Address: 61 Long Croft Street Huddersfield HD7 4EA

Application number: 2025/92628	
What is the application for?:	Erection of dwelling and associated works (within a Conservation Area)
Address of the site or building:	adj, 42, Long Croft Street, Golcar, Huddersfield, HD7 4EA
Postcode:	HD7 4EA

HOUSE TYPE 01 GA PLANS & ELEVATIONS 1:100 @ A1

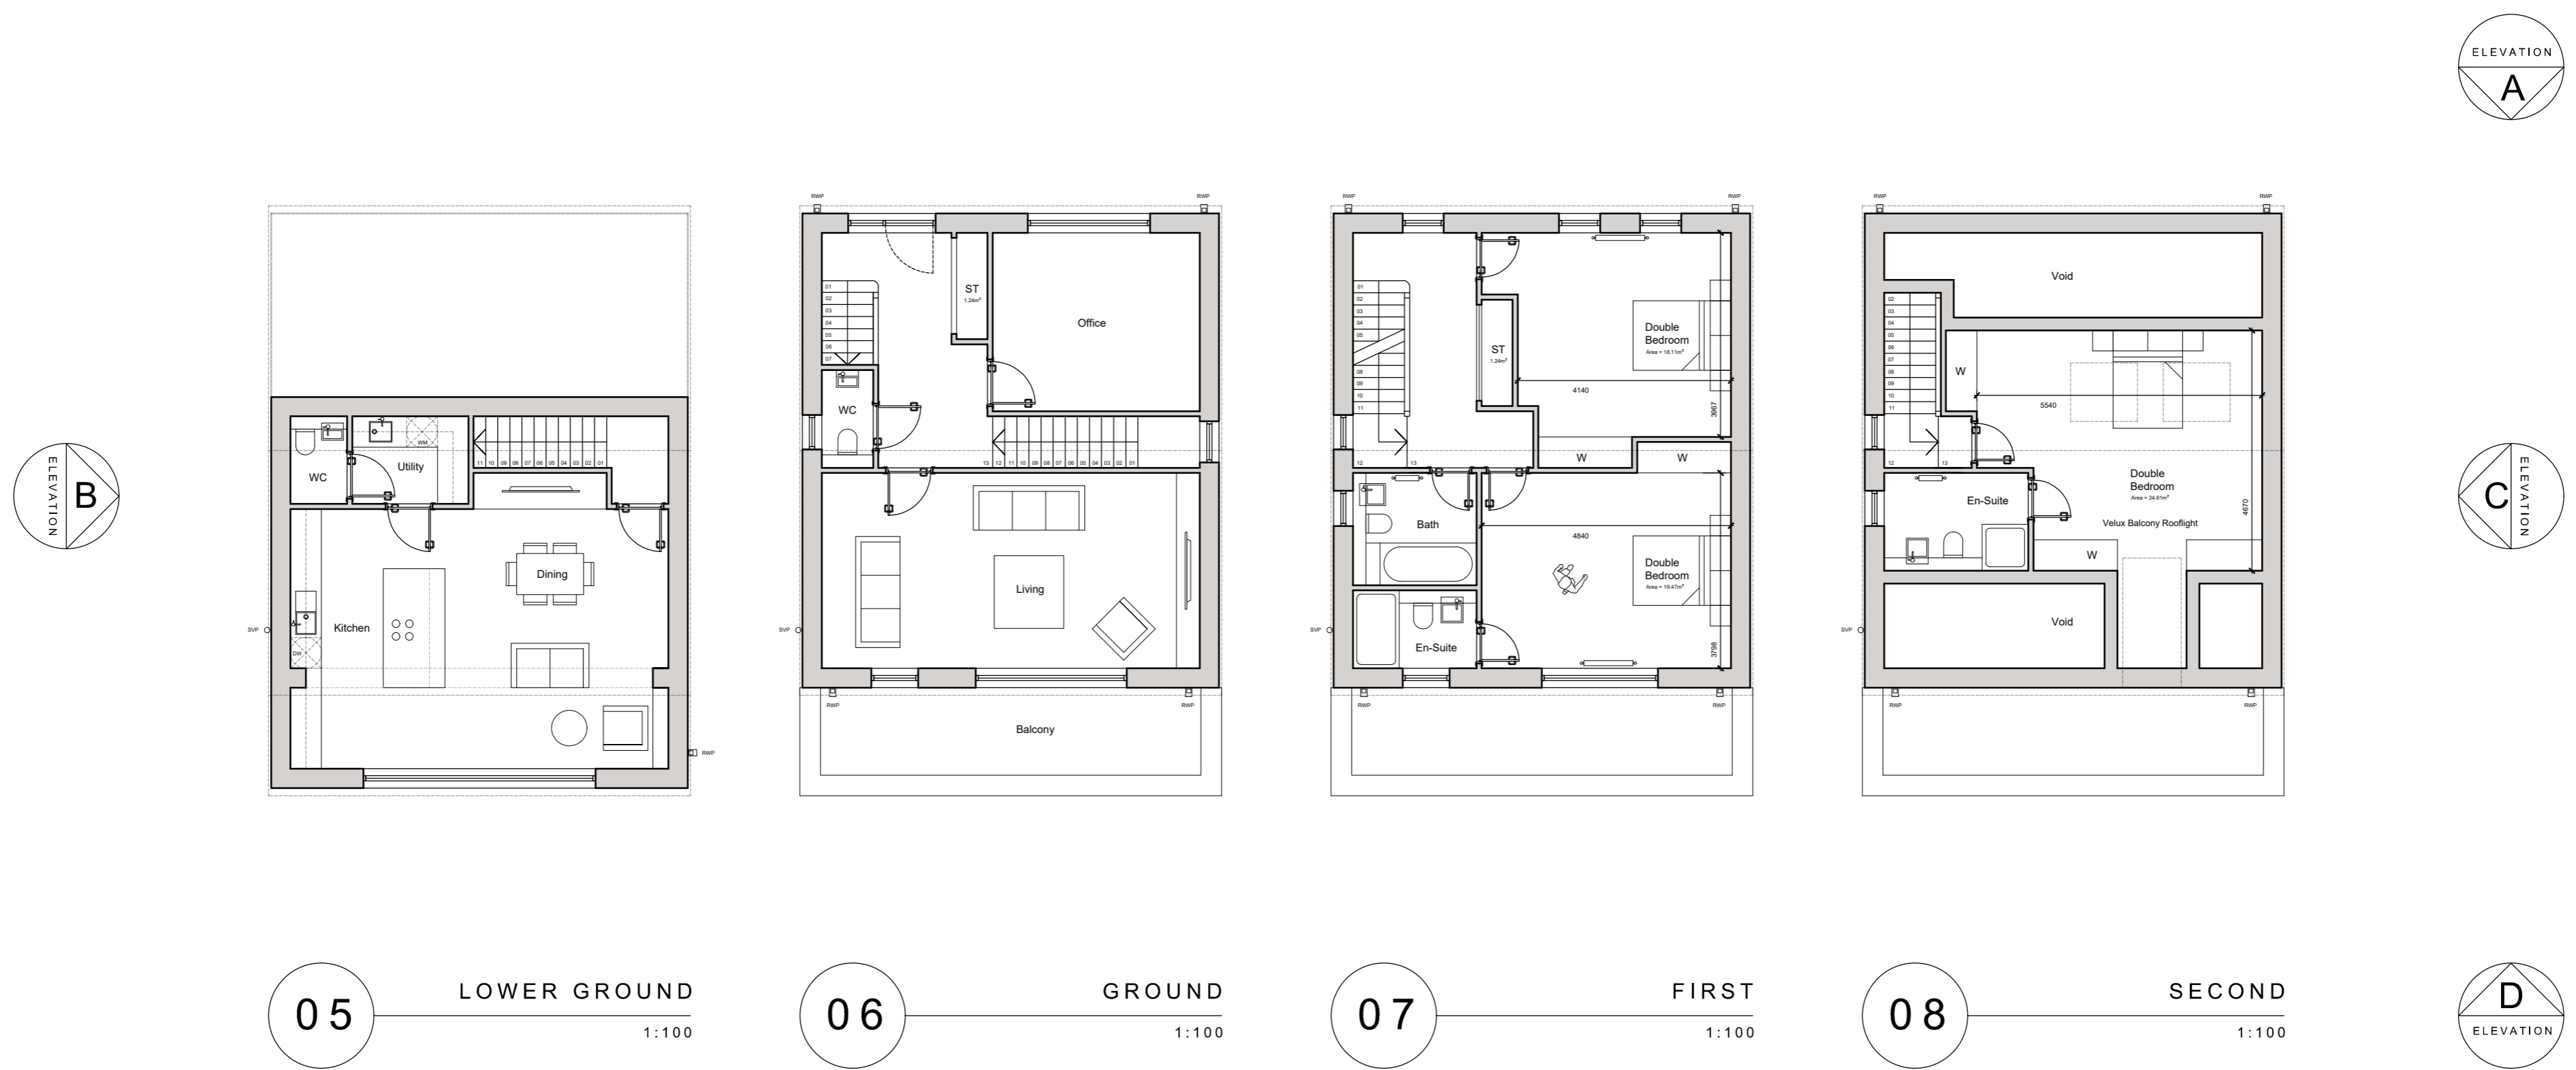
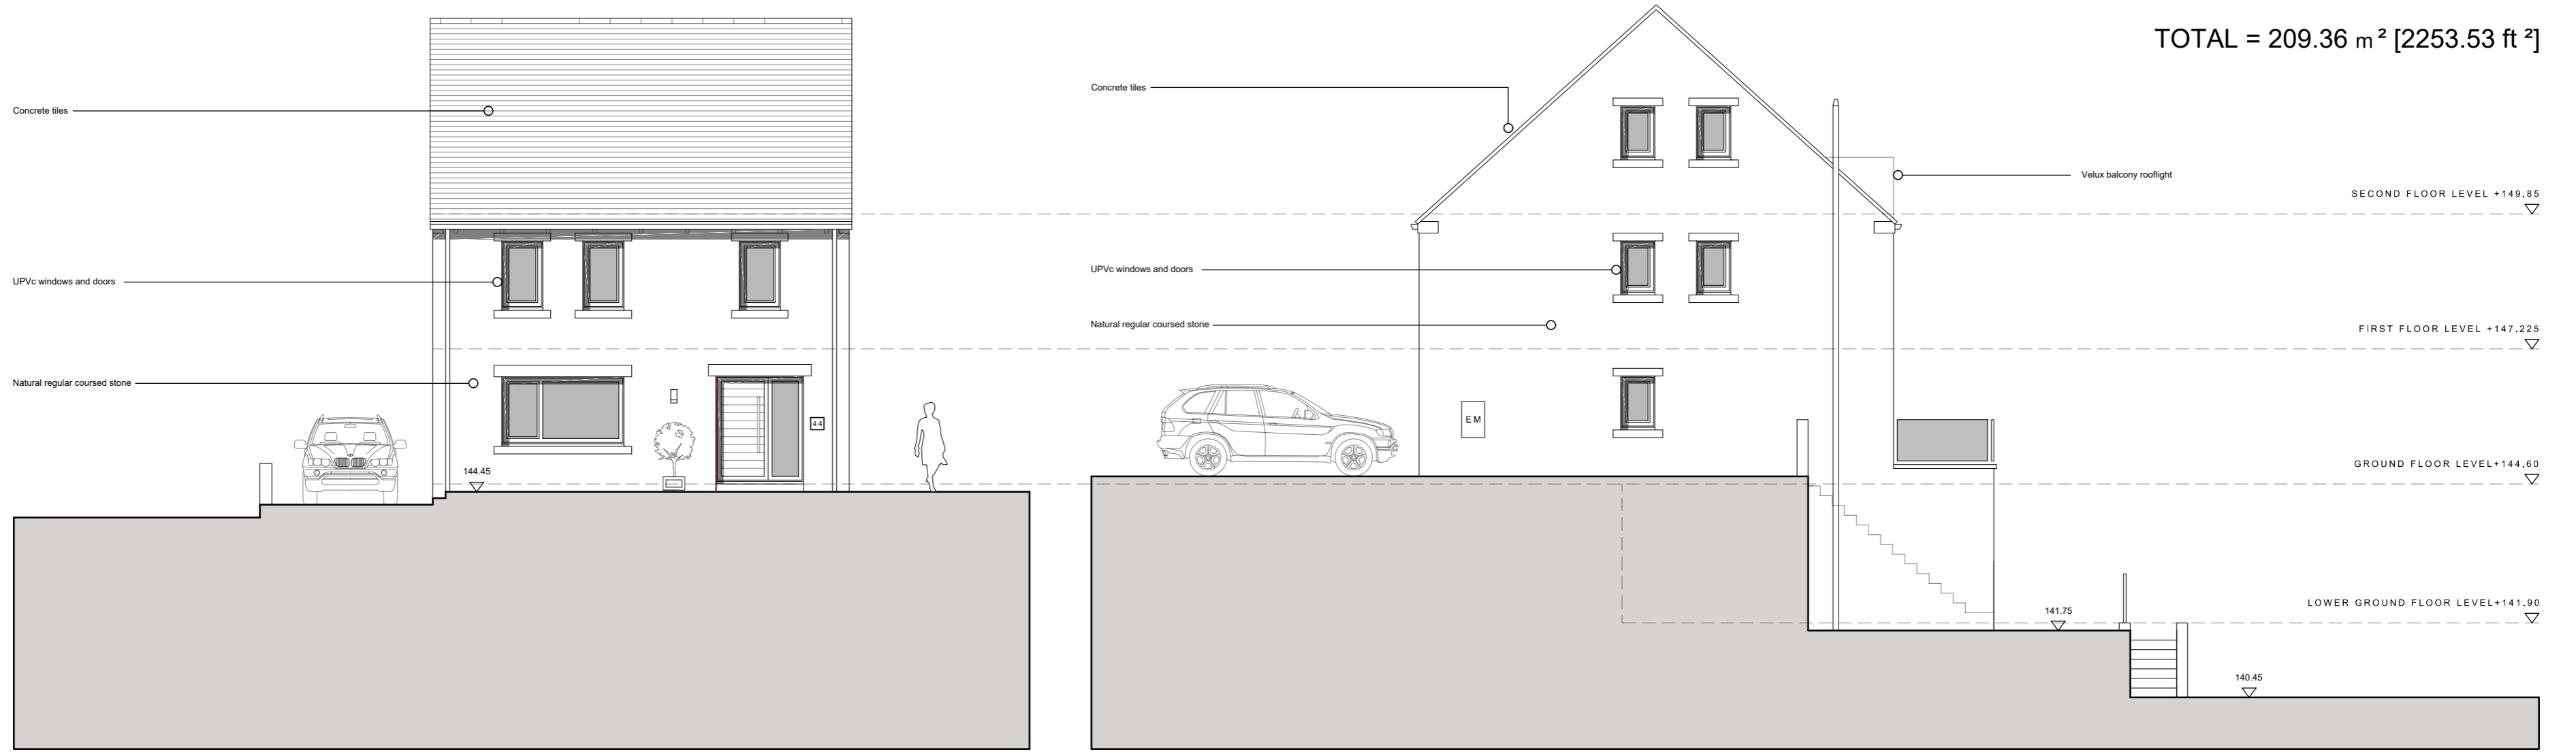
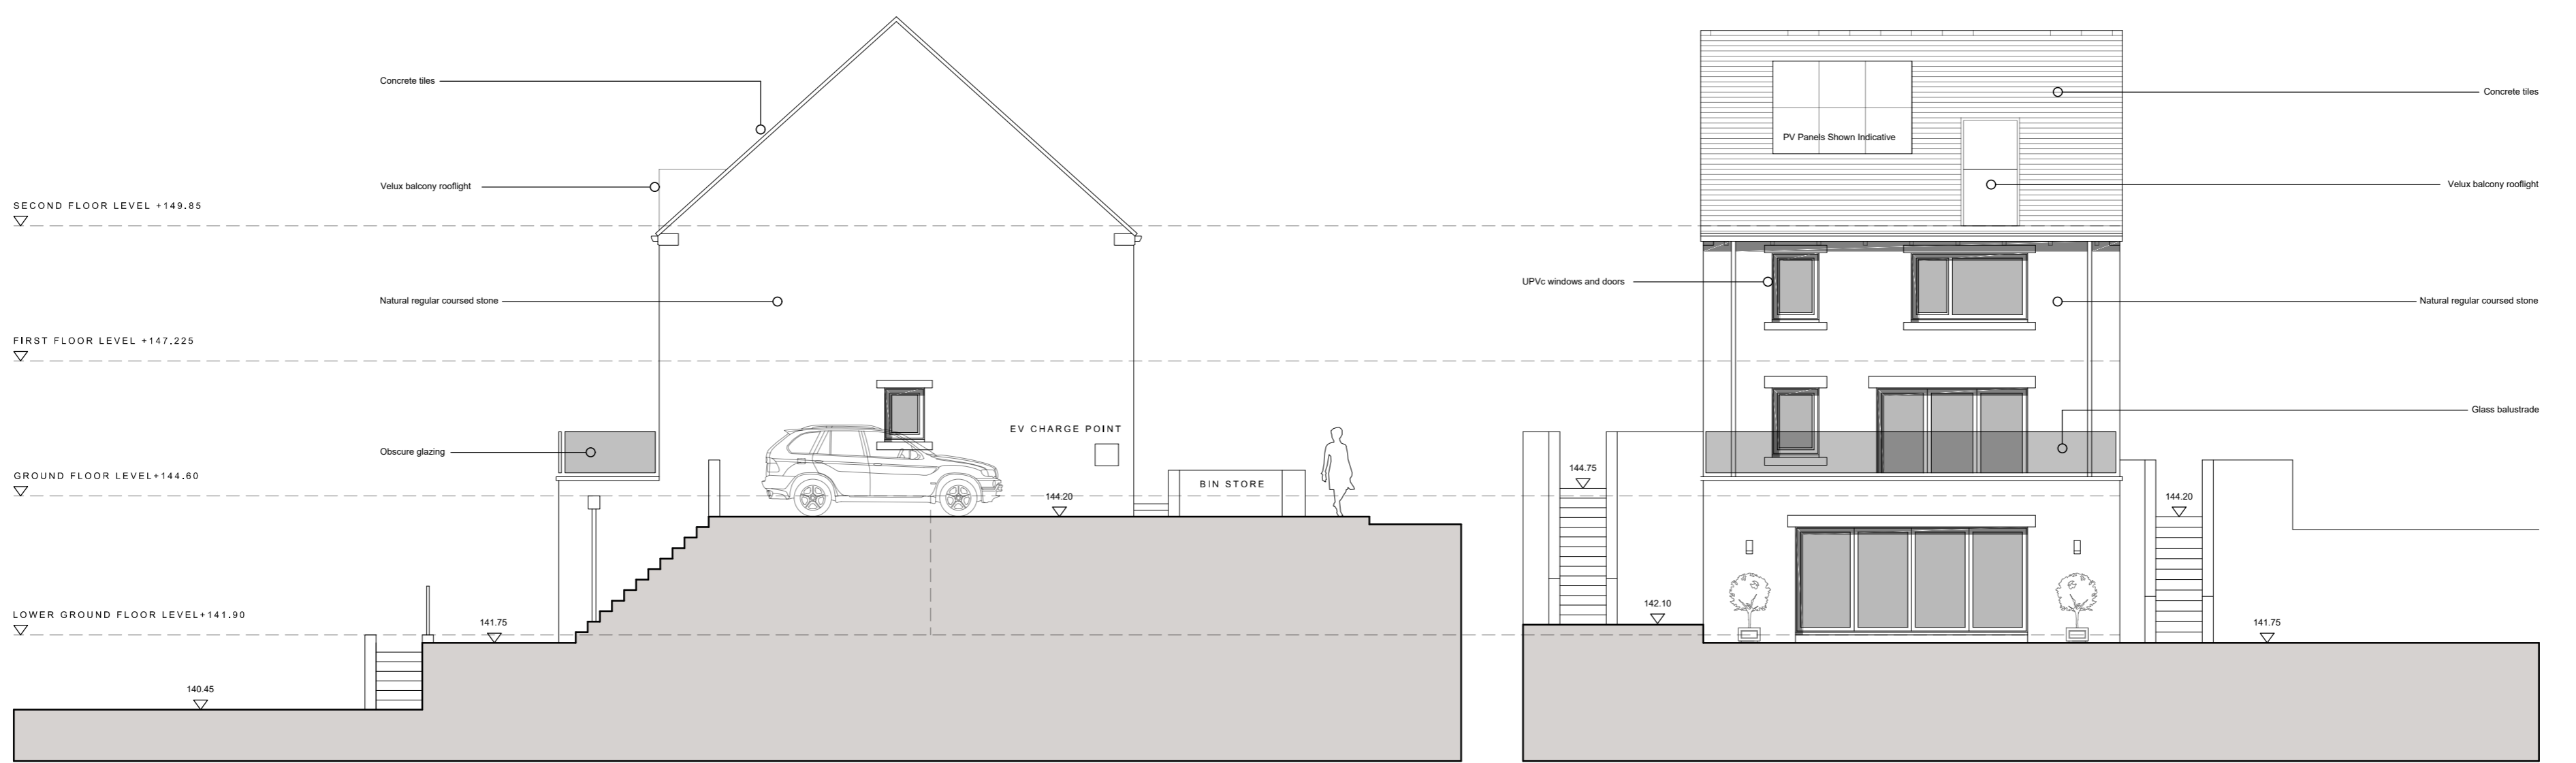
The scale and nature of the proposal constitutes an overdevelopment of the site, which fails to respect the local context.

The proposed mass and footprint appear disproportionate to the size of the plot and the surrounding pattern of development, leading to an overly dominant and visually intrusive structure. That is not in keeping with the valley image.
